Our Ref: BR/3/20/A
Your Ref:

Town & Country Planning (Control of Advertisement) (England) Regulations 2007 (as amended)
Application for Consent to Display an Advertisement(s)

Development 1 No. non illuminated fascia sign on front elevation.

Location 39 Bedford Street Bognor Regis

Proposed Elevation - Advertising
No changes except

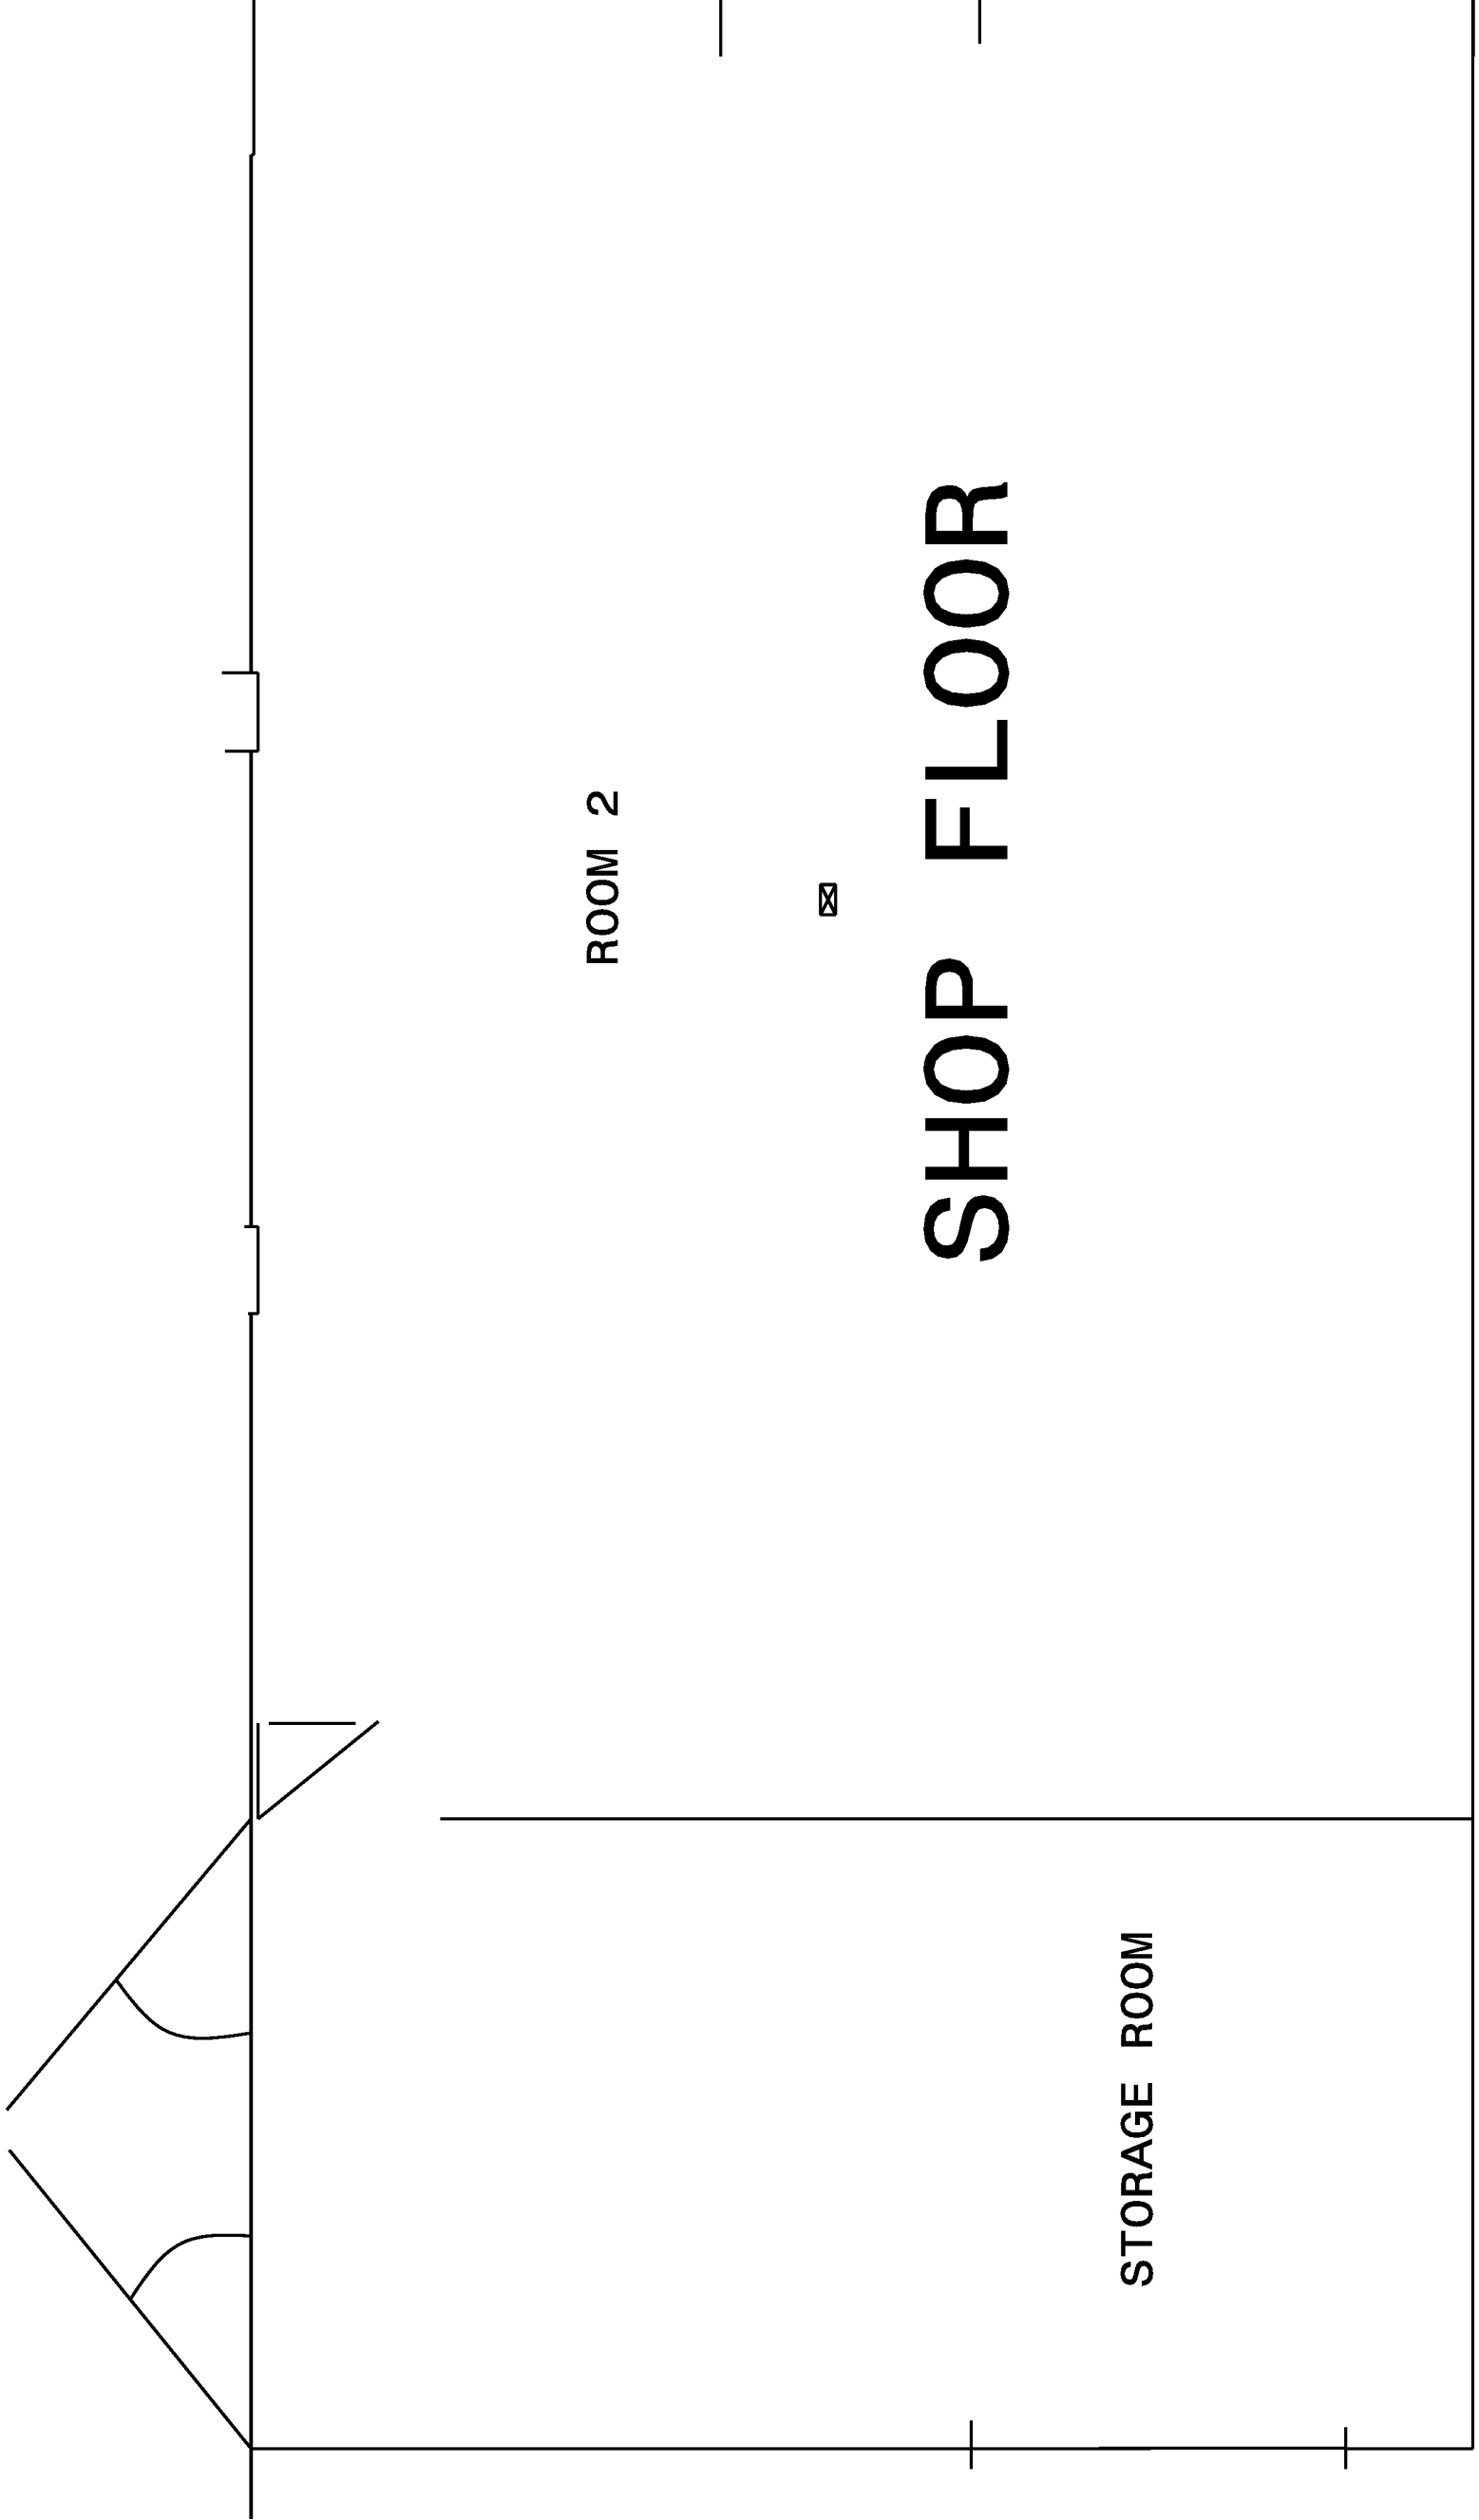
Please provide measurements (length, width, height for the actual fascia sign and proposed lettering) for the proposed fascia sign on the photo that was submitted.
